Application No: AW/3/21/HH
Site Address: 4 Shorecroft Aldwick PO21 4AS
Description of works: Single storey rear extension and loft conversion with enlarged rear dormer window and two modest front facing dormer windows. Alterations to fenestration, Canopy to side elevation, Planter and replacement handrail to roof terrace.

Thank you for your internet representation made on 28th January 2021 which has been recorded as an objection with the comments as follows:

Drawing No. Date:
C.1062H - 04 22-12-20

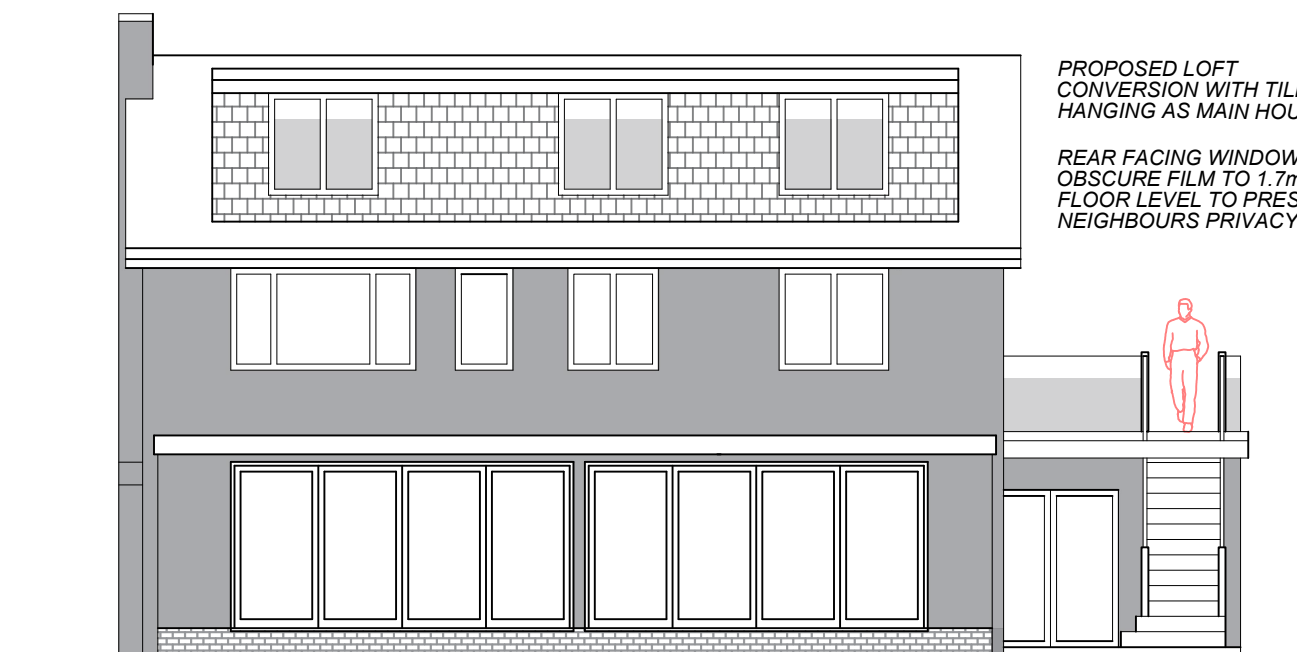
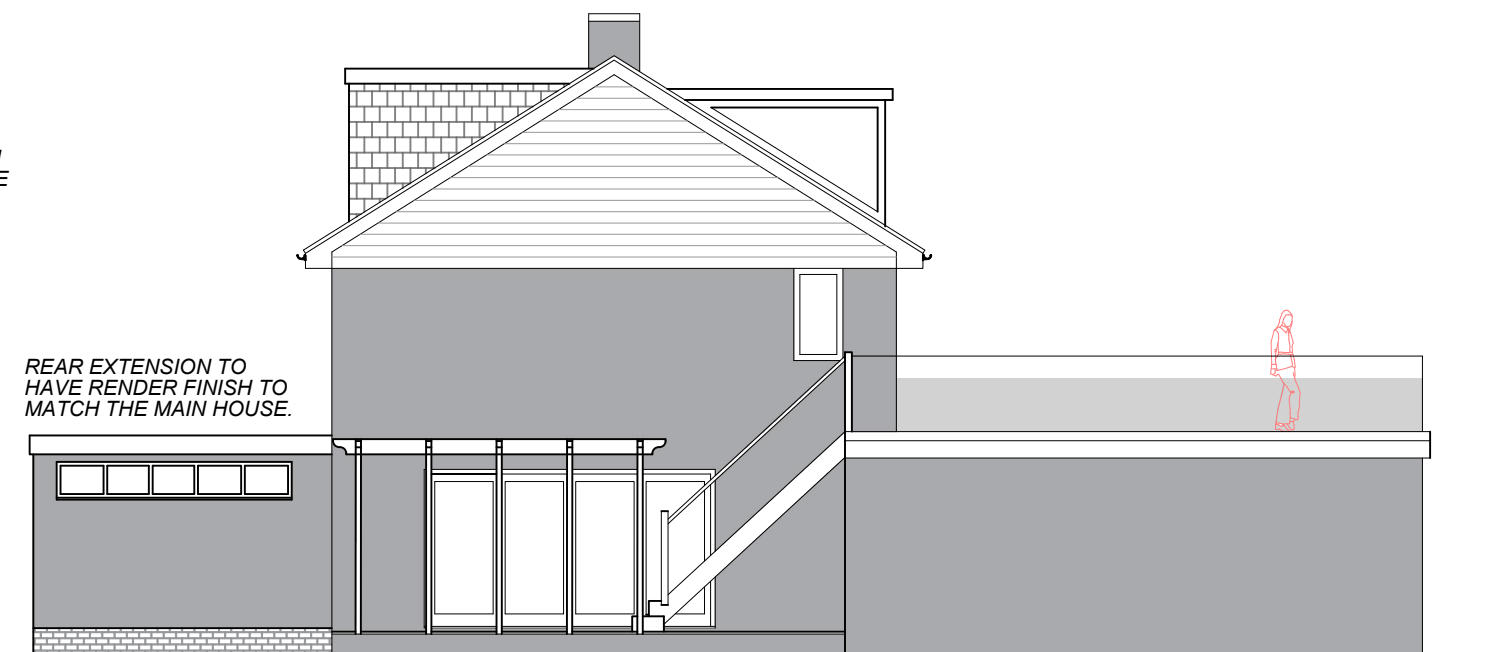
1.1 Screening of neighbouring properties by obscure film does not protect privacy. Window film can be removed and therefore is not a permanent solution.

1.2 Partially obscuring windows will still allow clear sight of neighbouring amenity. Loft glazing needs to be fully obscure glass and fixed or restricted opening.

1.3 Viewing angle from increased height will result in an unacceptable loss of privacy of the three bungalows in Aldwick Place.

2.1 This roof extension would have a dramatic impact on our quality of life as this box dormer structure would have intrusive views of our living rooms and rear garden space, particularly the patio area which is in constant use.

3.1 Planned rear roof extension would be totally overbearing due to its bulk and appearance and would overwhelm the three bungalows that it backs onto.

PROPOSED ROOF PLAN

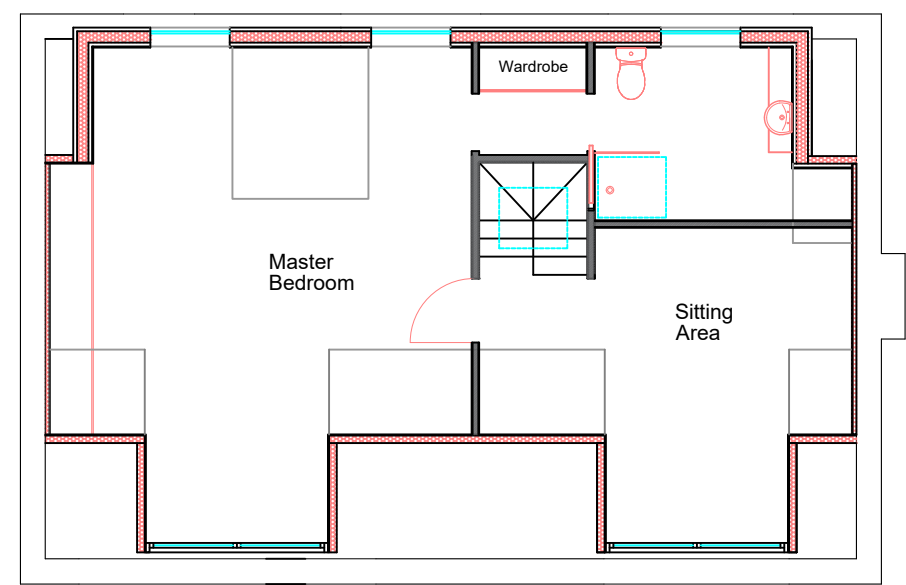
3.4 Planning guidance state that large flat roofed dormers are rarely accepted.

4.1 Velux roof lights that follow the existing roof line are a common feature of loft conversions and would be an acceptable solution. This also would not compromise neighbours privacy and amenity.
